KIRKLEES METROPOLITAN COUNCIL INVESTMENT & REGENERATION SERVICE

Reference No:	2021/44/92901/W
Site Address:	Former Midlothian Garage, New Mill Road, Holmfirth, HD9 7LN
Description:	Discharge of conditions 5 (junction works) and 8 (internal estate roads) of previous outline permission 2015/93824 for erection of 56 dwellings and care home with associated car parking
Recommending Officer:	Nick Hirst

DECISION – Discharge of Conditions – Refuse

Report Dated: 23/08/2024.

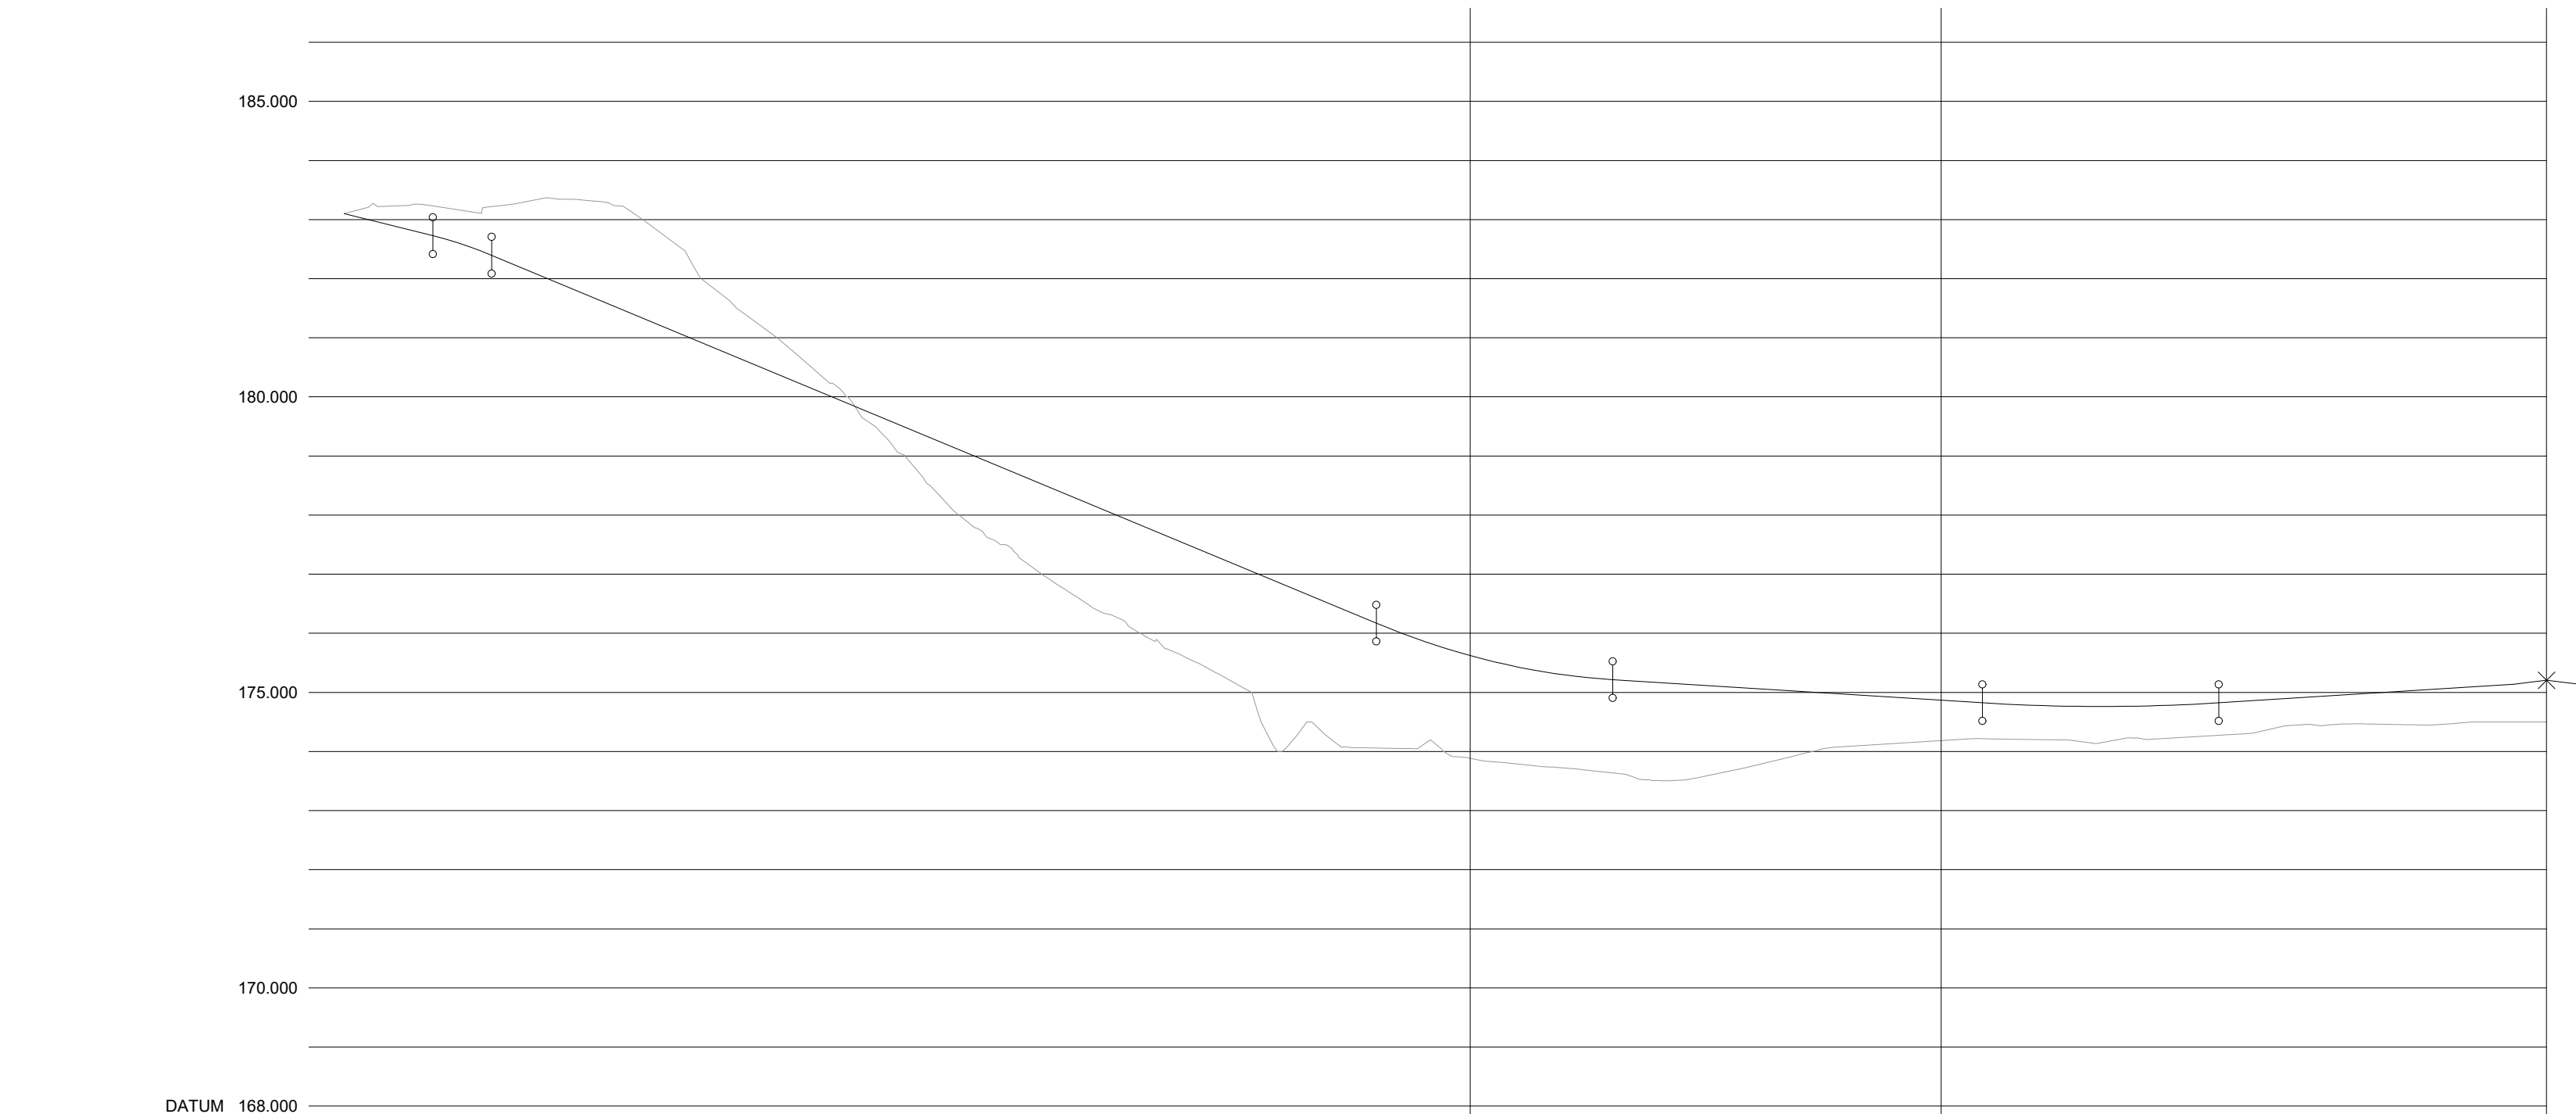
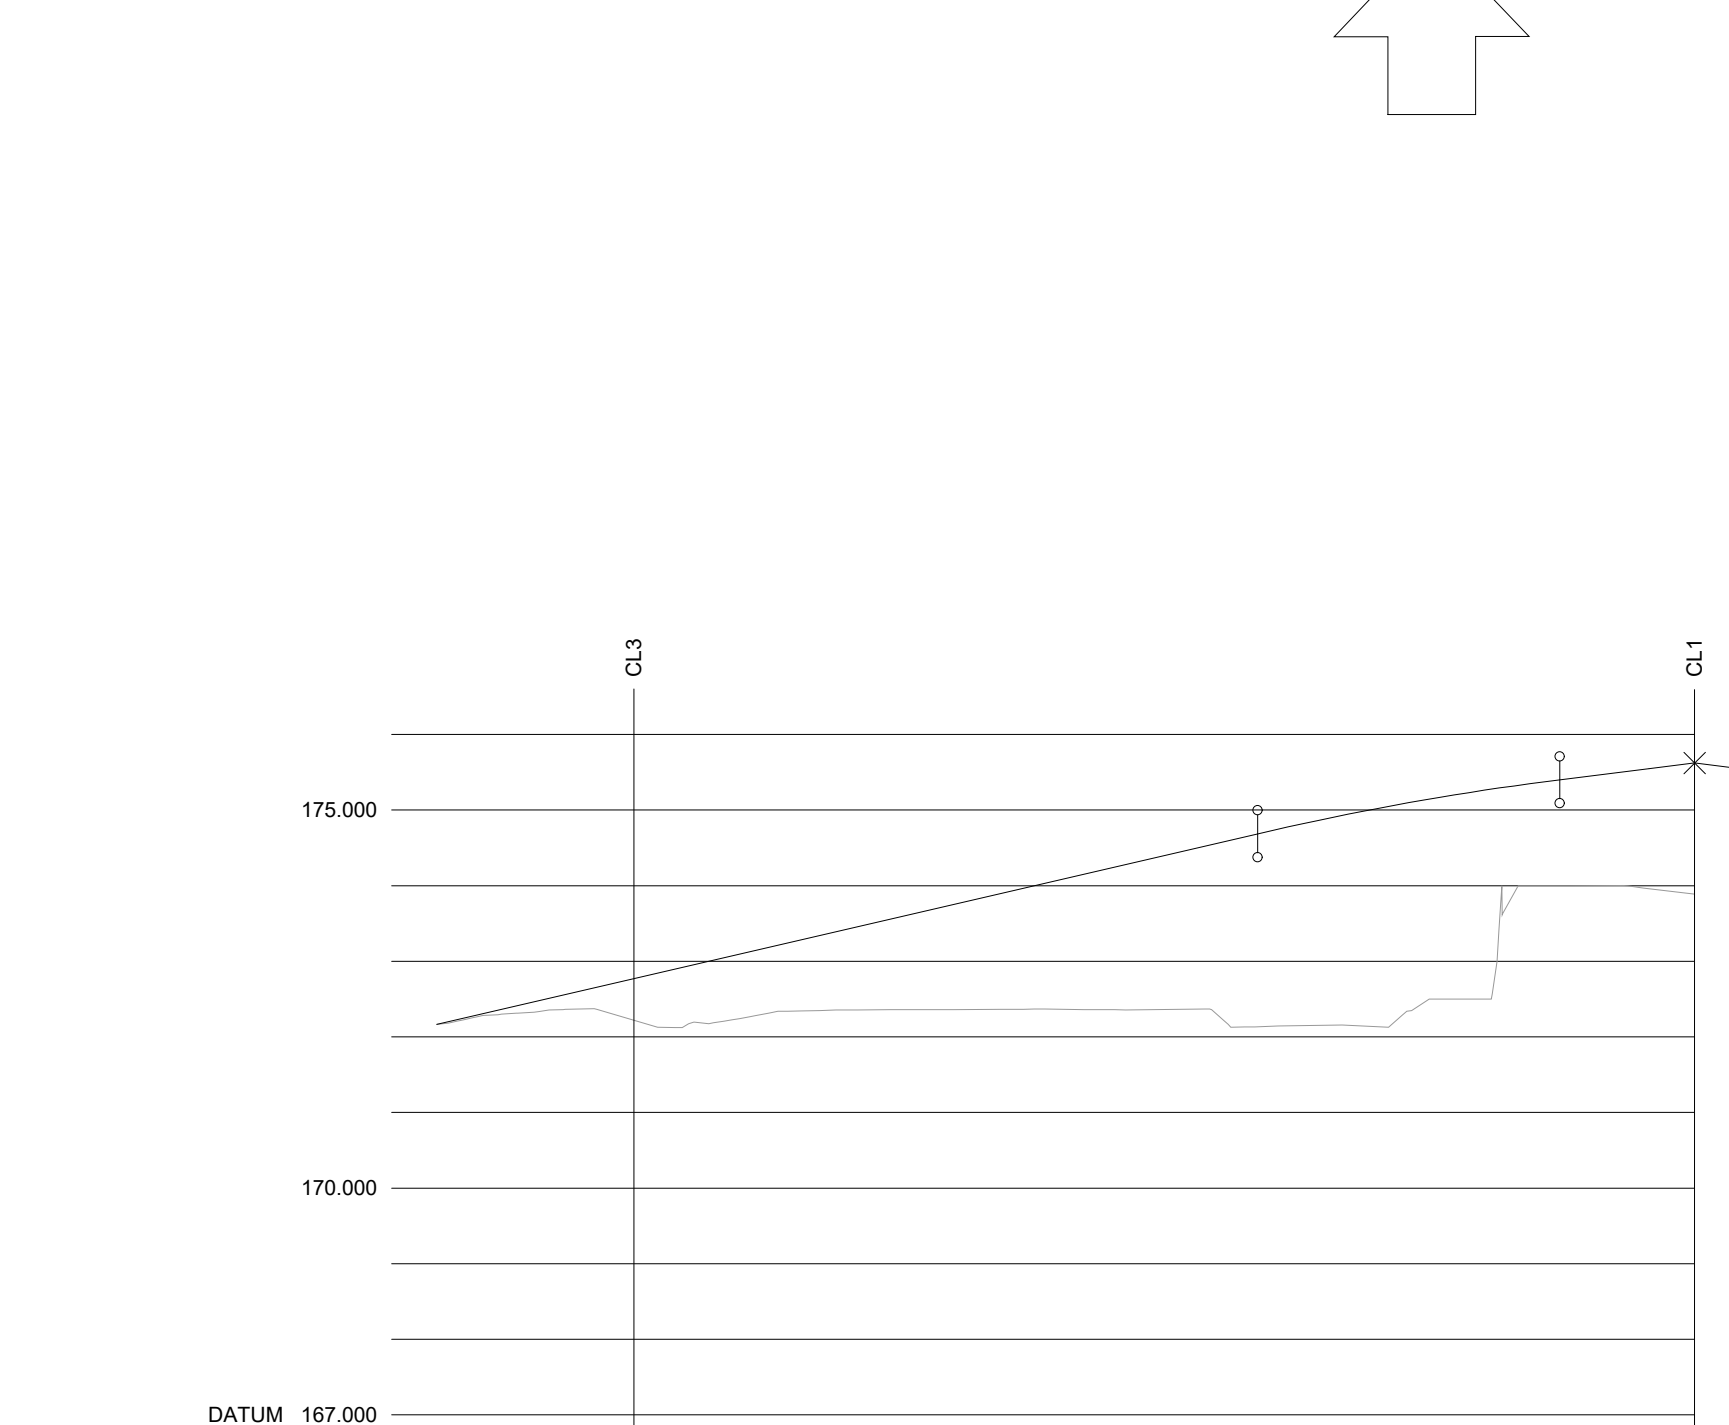
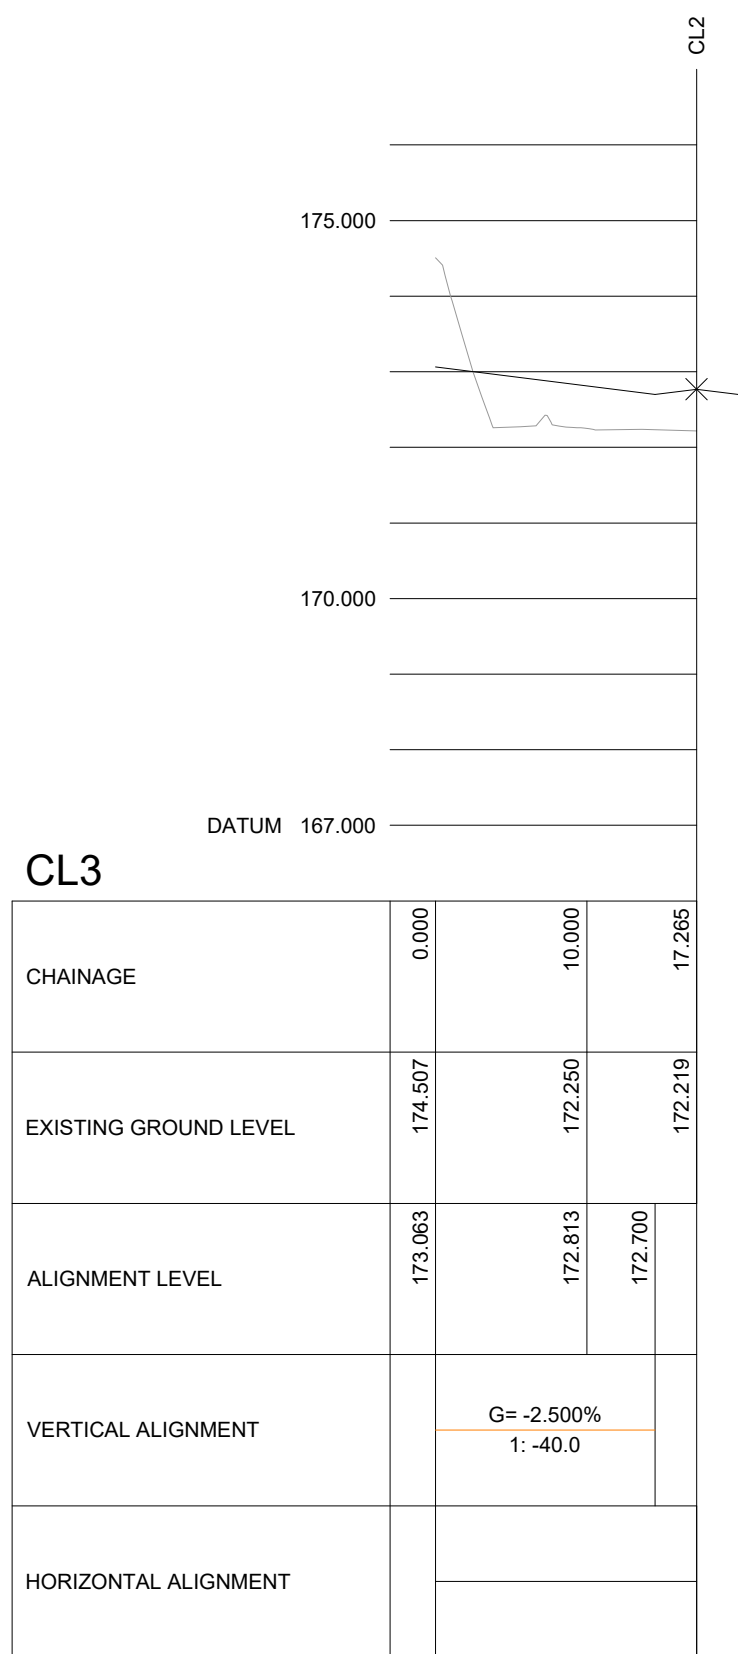
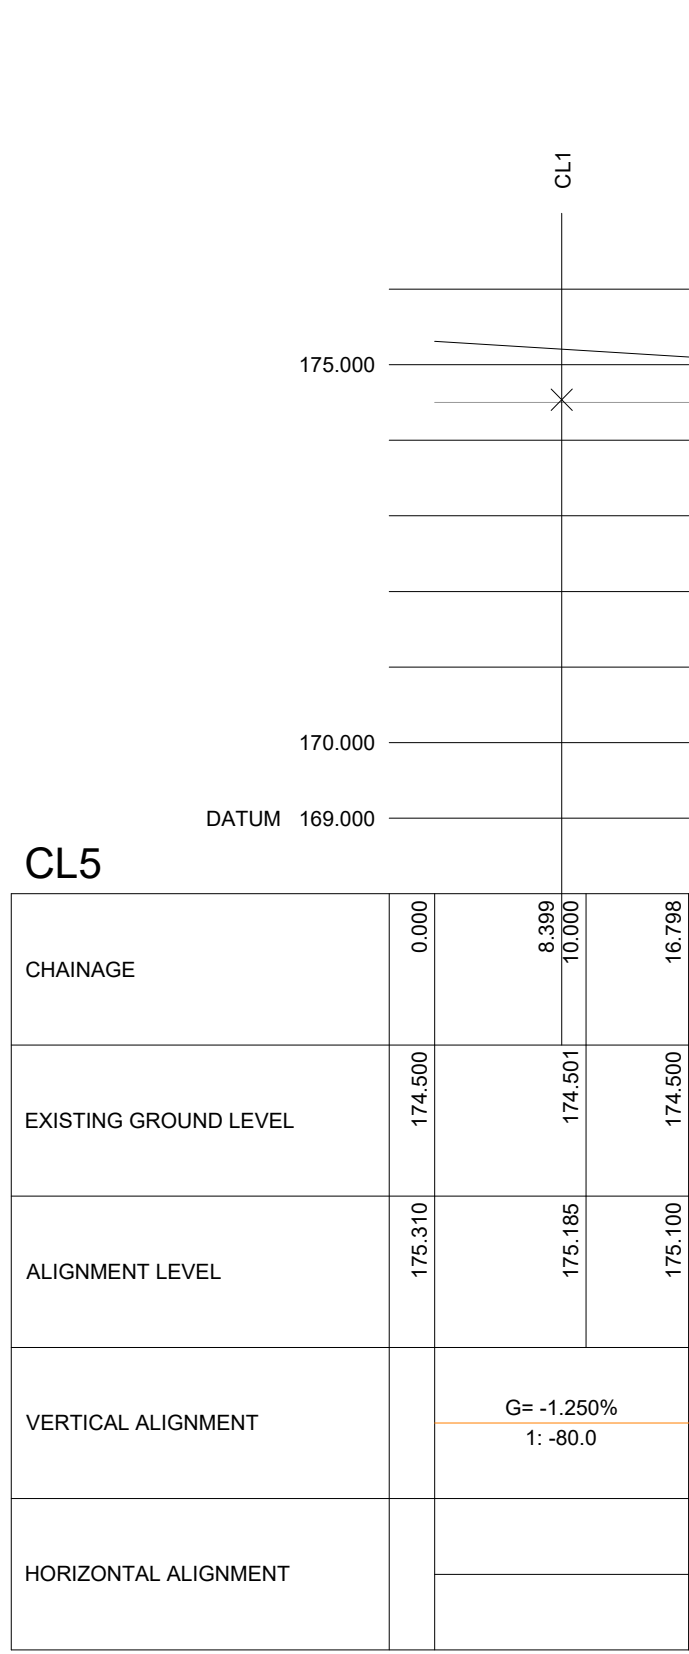
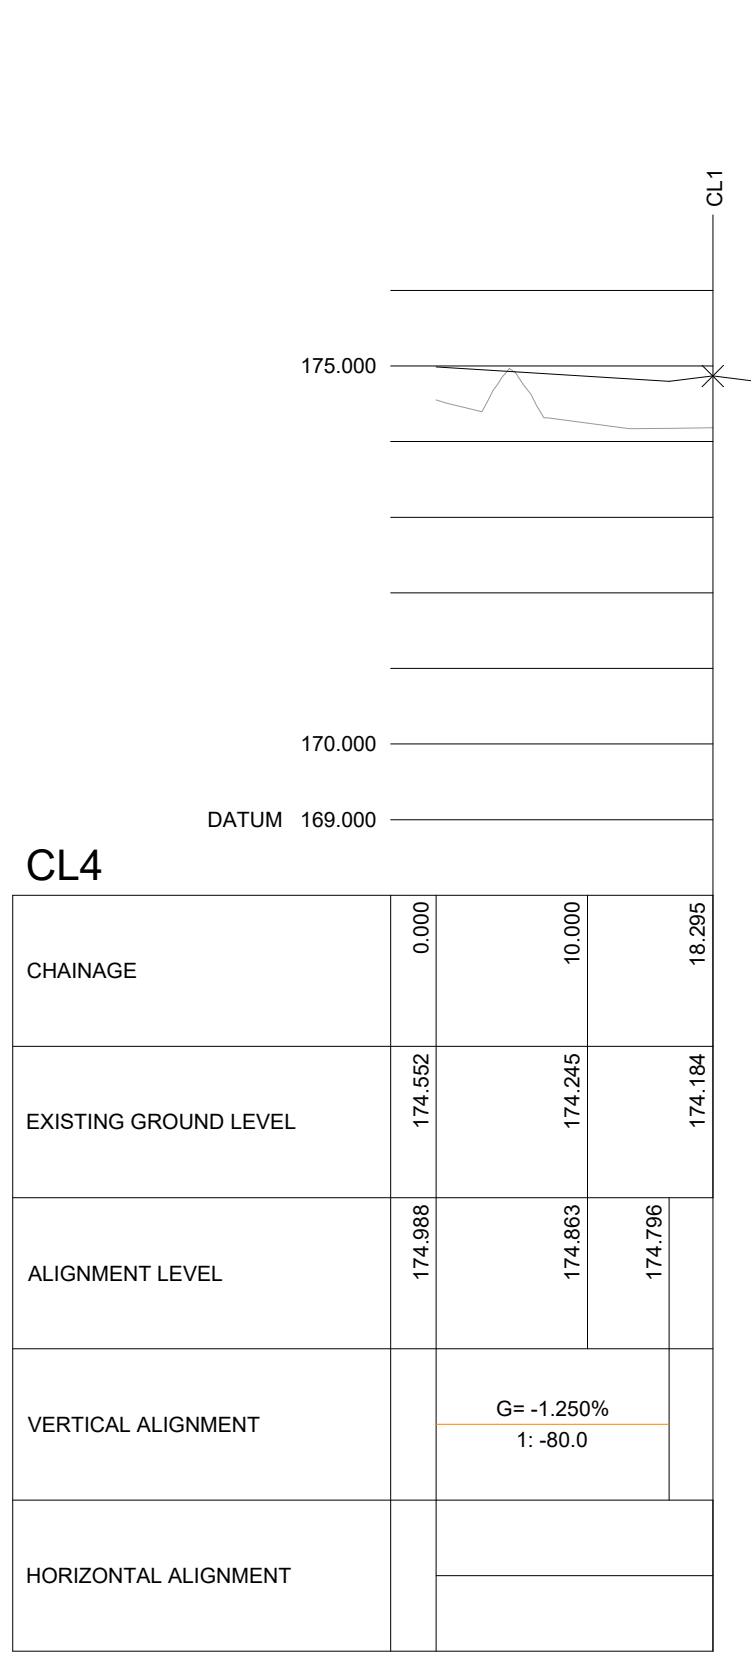
- There is a lack of cross-sectional information, particularly relating to highway retaining features;
- The drainage proposals are not satisfactory, including unacceptable gully locations and road levels/contours;
